Application No: A/164/21/AG
Site Address: Land south of Littlehampton Road Angmering BN12 6PN
Description of works: Notification under the Town & Country Planning (General Permitted Development)(England) Order 2015 under Schedule 2, Part 6, Class B(d) to upgrade existing agricultural track, providing access to Roundstone Farm.

Thank you for your internet representation made on 26th August 2021 which has been recorded as an objection with the comments as follows:

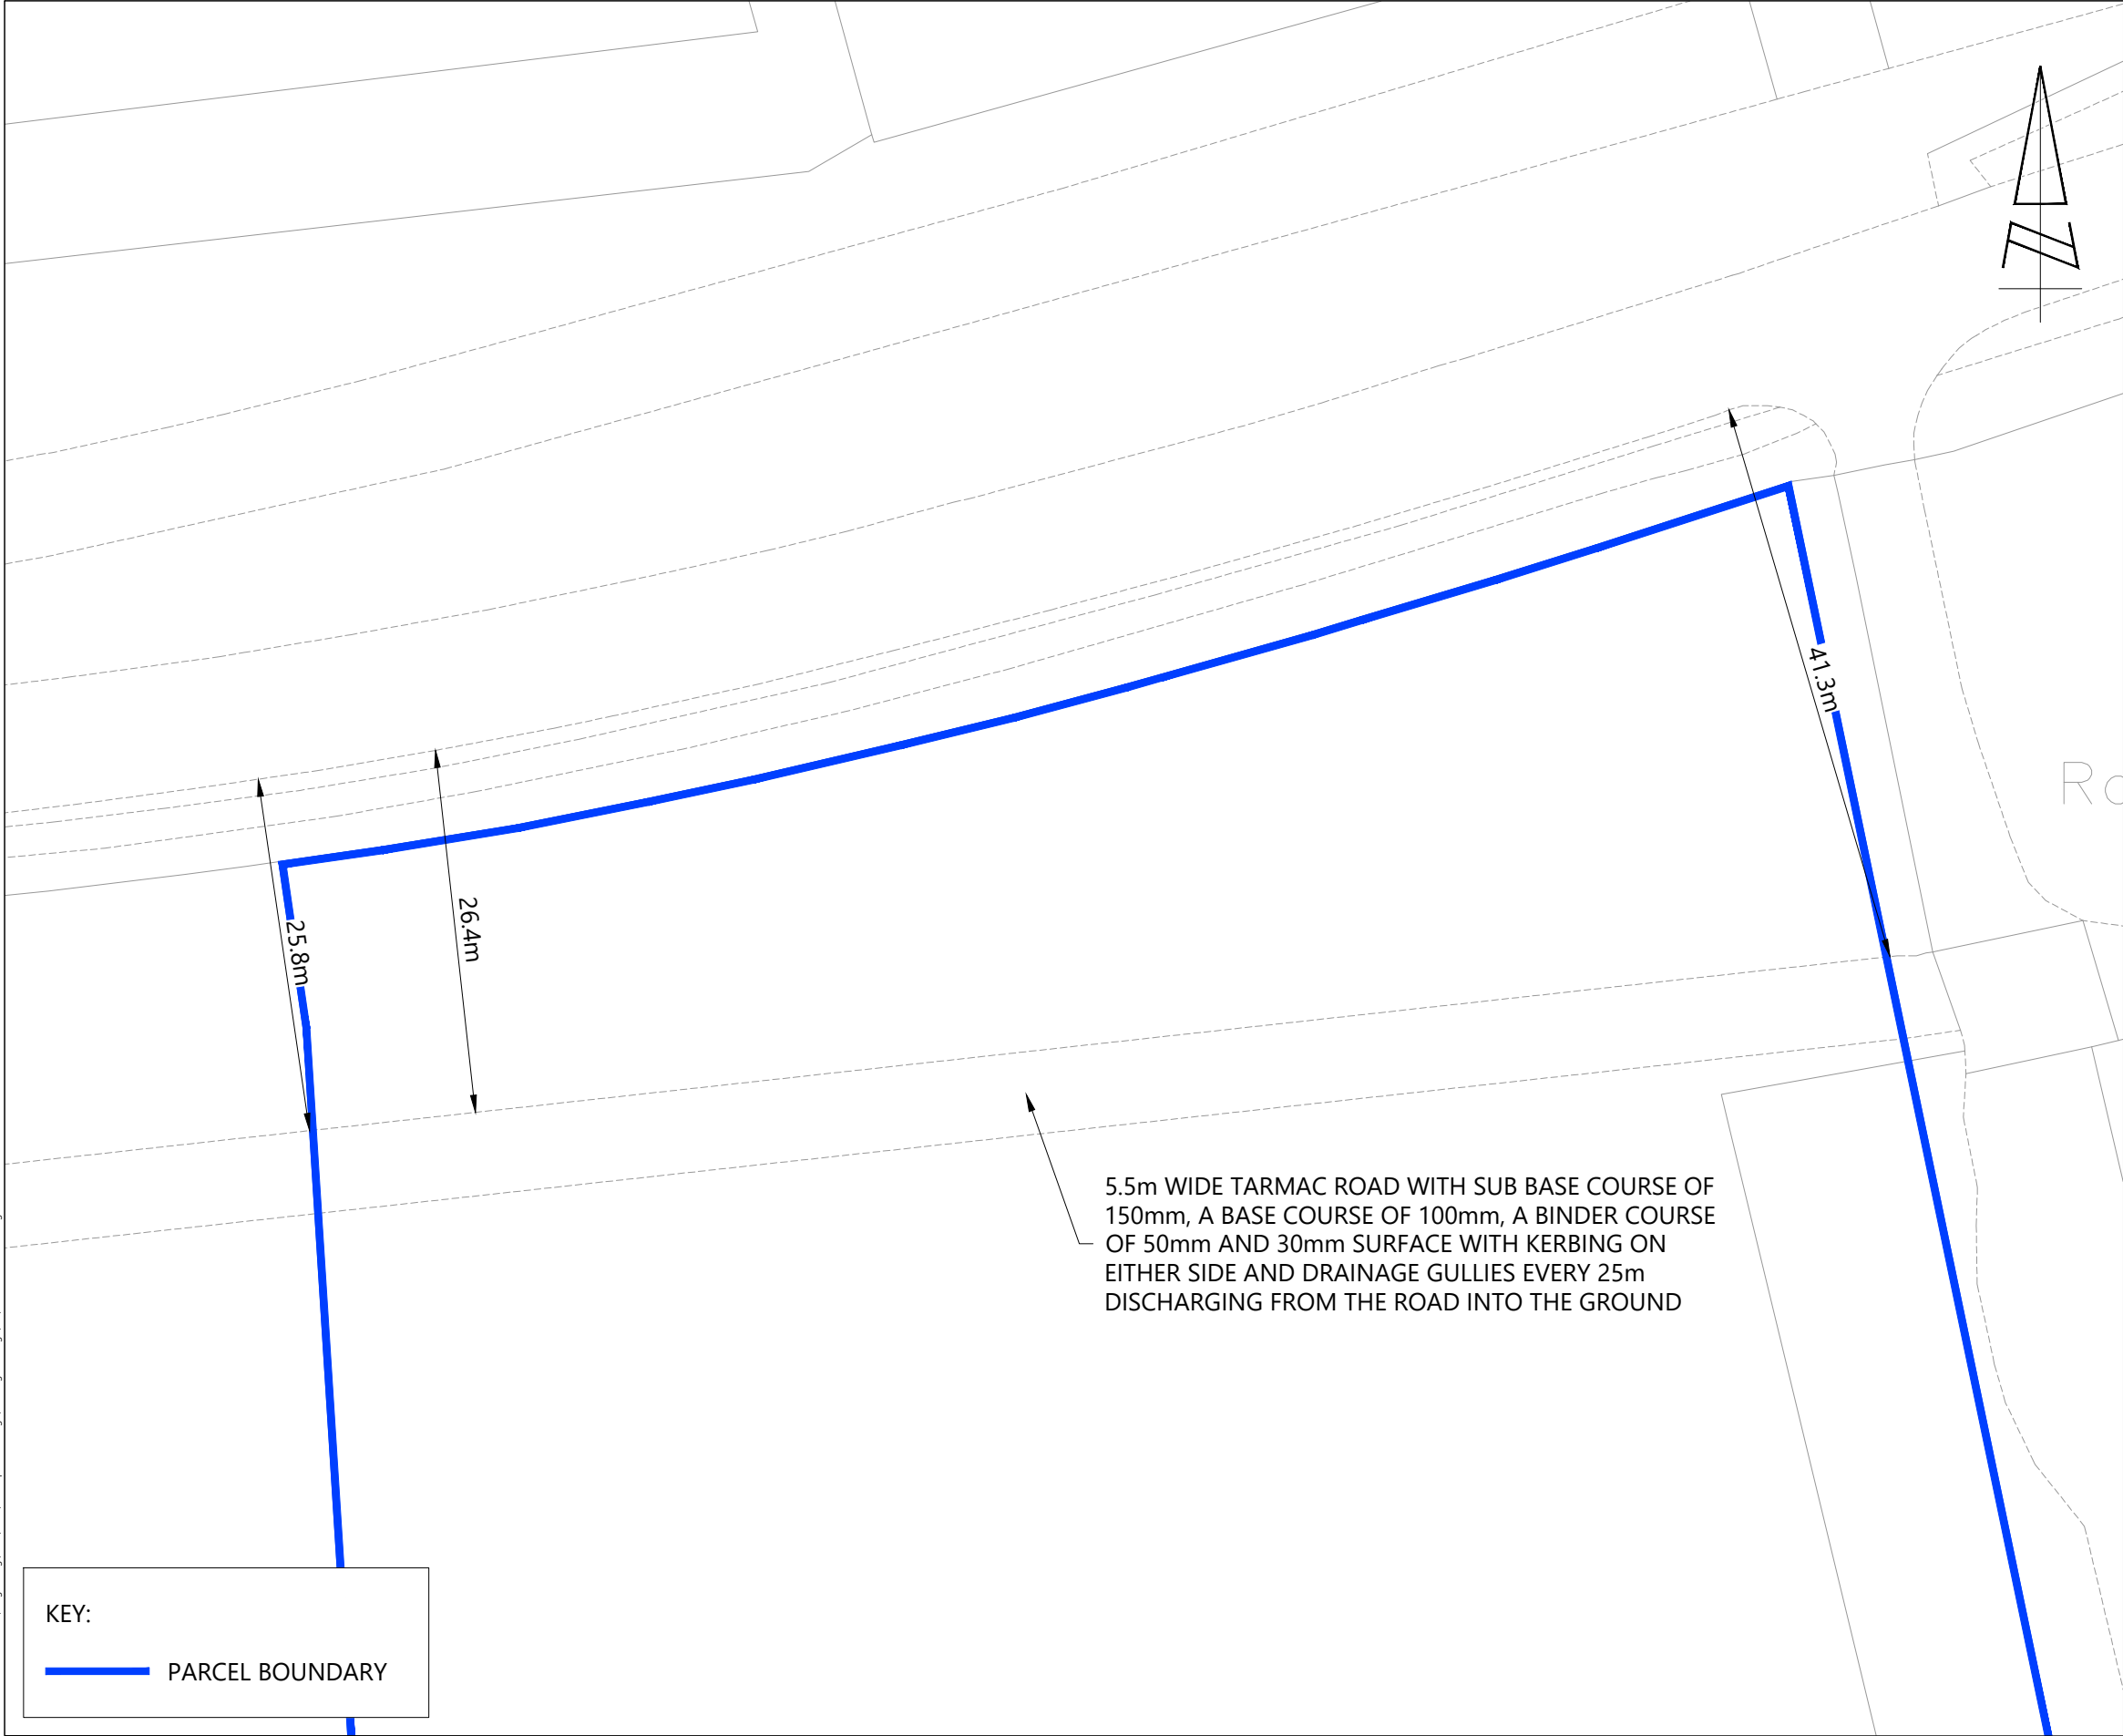
The extent of the proposed upgrade to the 'farm track' for agricultural vehicle access would appear excessive and effectively change the nature of the existing field. The fact that it being made by a major housing developer with an interest in the site raises further concerns about the future intentions for the field.

It is noted that following the many objections and concerns already submitted, the Case Officer has now sought clarification from Redrow Homes in an e-mail dated 18th August 2021. The applicant has confirmed that "the part of the track included within this application only being available for use by the farmer". It does not stipulate what use that may extend to.

Consequently, should Arun District Council be minded to approve this (seemingly) unnecessary level of upgrade to this section of the track, we would request that it is made with conditions to restrict its future use specifically to the farmer for agricultural vehicles only as required for the farm's agricultural activities.
